Application No: FG/37/22/PL
Site Address: 61 Sea Lane Gardens Ferring BN12 5EG
Description of works: 1 No dwelling. This site is in CIL Zone 4 and is CIL Liable as new dwelling.

Thank you for your internet representation made on 24th March 2022 which has been recorded as an objection with the comments as follows:

Further to our recent comments, we have reviewed the proposed plan and have additional comments to add. Our decision is now an objection.

Client:		
Address of Works: 61 Sea Lane Gardens Ferring West Sussex BN12 4TB		
Drawing Title: Proposed Dwelling Planning		
Paper Size: A3	Date: Dec. 2021	
Job Number: AR-165B	Drawing Number: 01	Revision: Revision

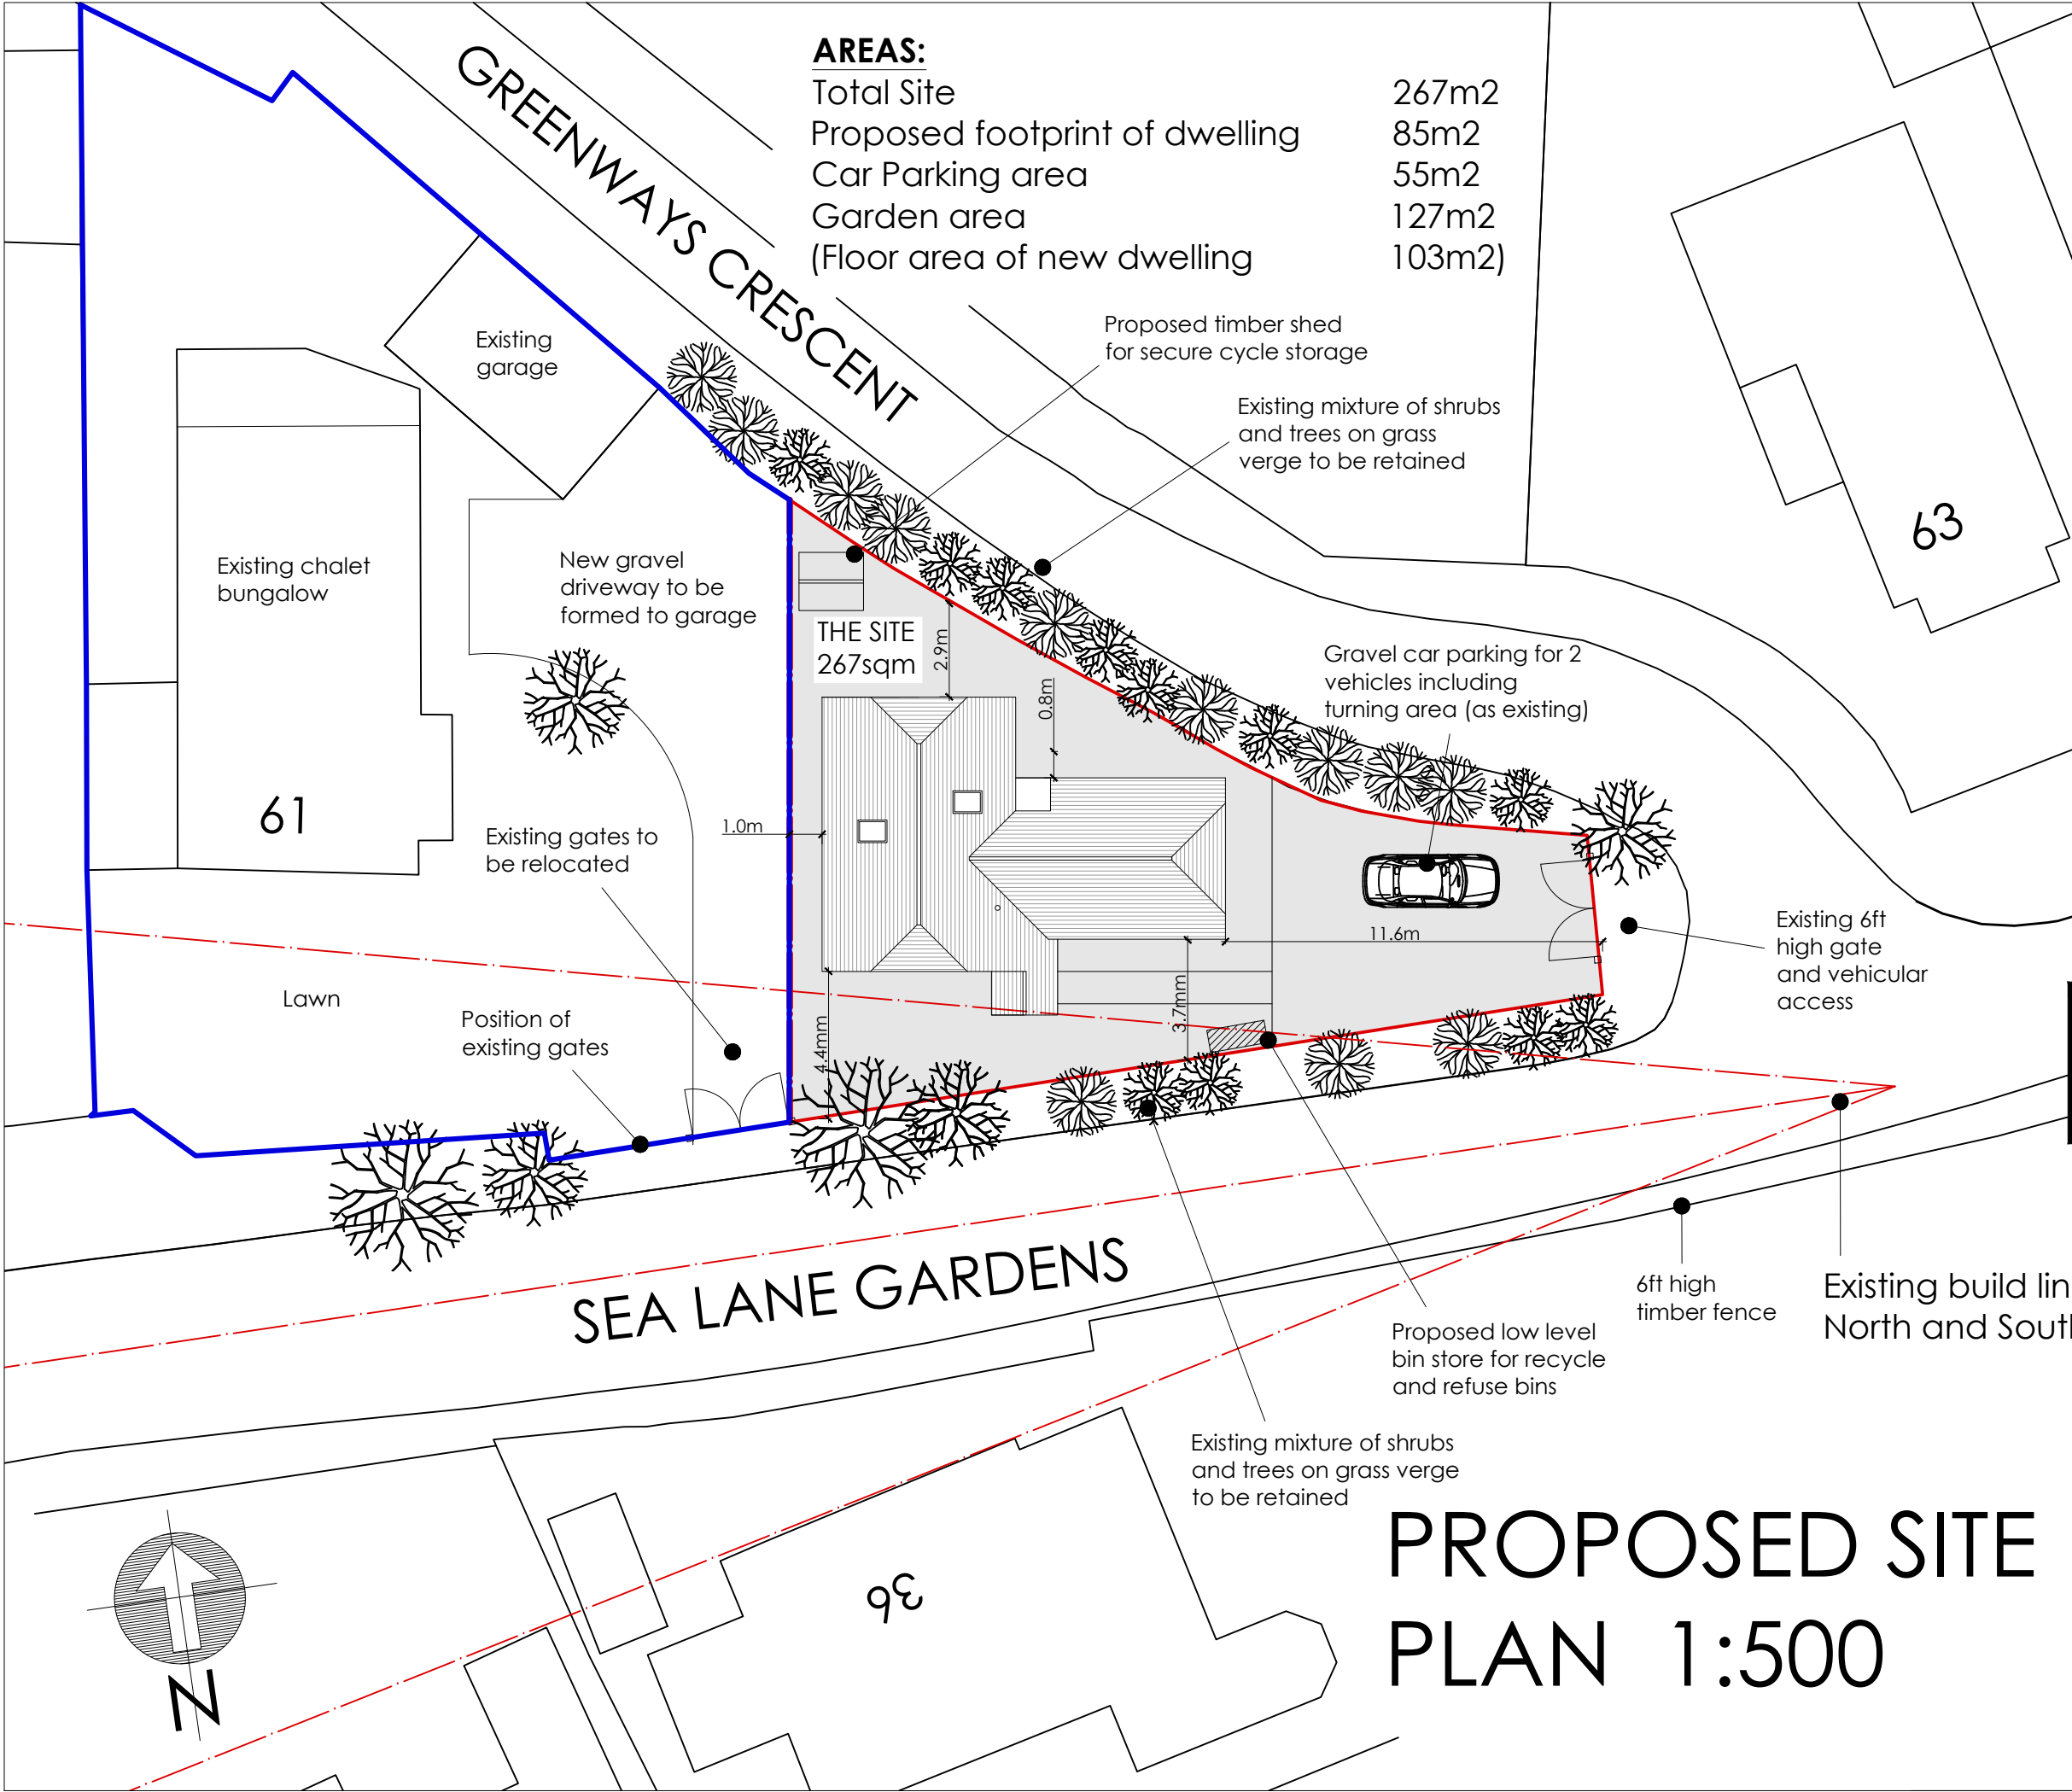
1. The proposed plan shows trees and shrubs which will remain around the boundaries.

Currently two trees have been lost in the recent storm on the south side.

Also the overarching tree at the access to Greenways Crescent was cut down on the evening of the 19th March 2022 and is now an unsightly stump.

The loss of this tree has left a wide-open space and there are several dead trees that may come down in a further storm. These changes make the proposed plan out of date as the property will not be screened by trees.

3. 6-foot-high fences/gates shown on the proposed plan do not exist. Existing Gate is low level.

4. We have been brought to our attention by a long-term resident that there was a well and pond on the existing gravel drive.

5. Location of the new build on the plan shows fencing close to the boundary fences, no garage, and no garden.

# PROPOSED CAR PARKING PLAN 1:50

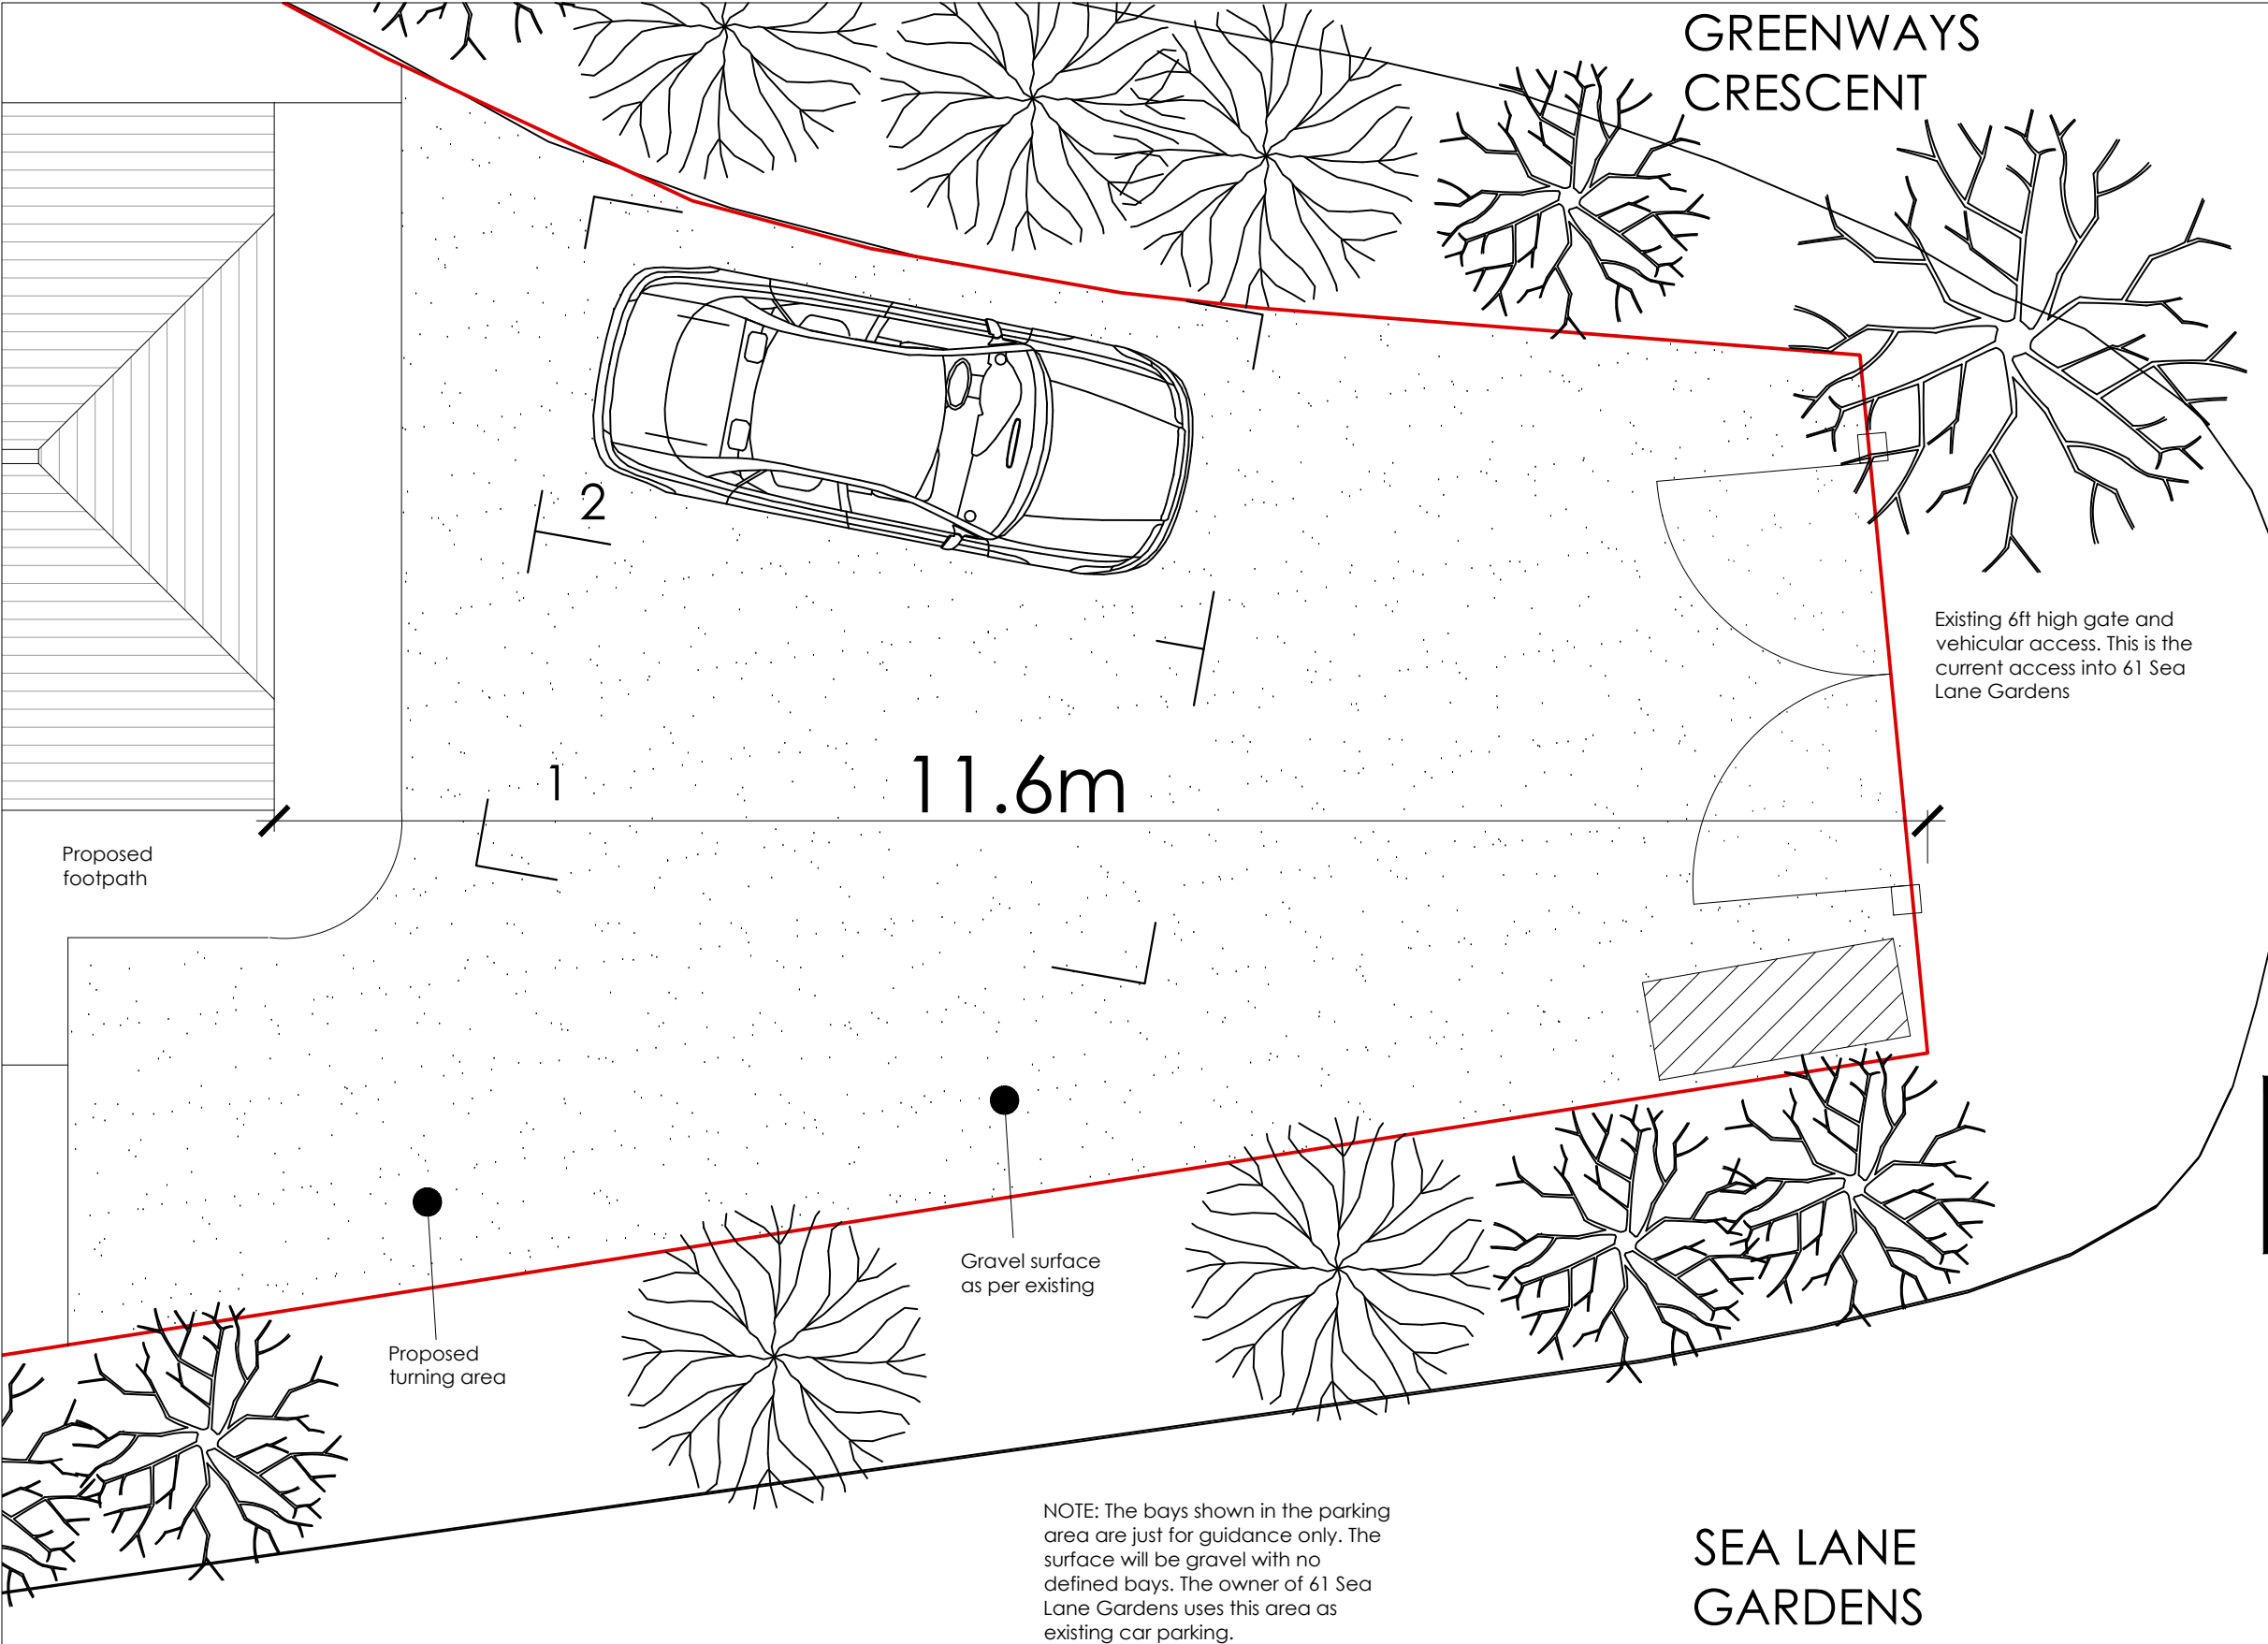
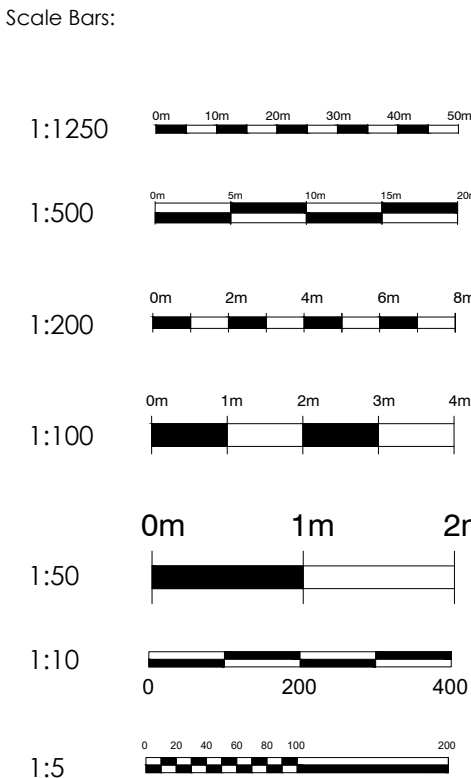
6. Gravel parking area only shows one car. Turning area is not large enough for a second car to turn round. If the car backed out in reverse, it could be dangerous from cars coming down from Greenways Crescent.
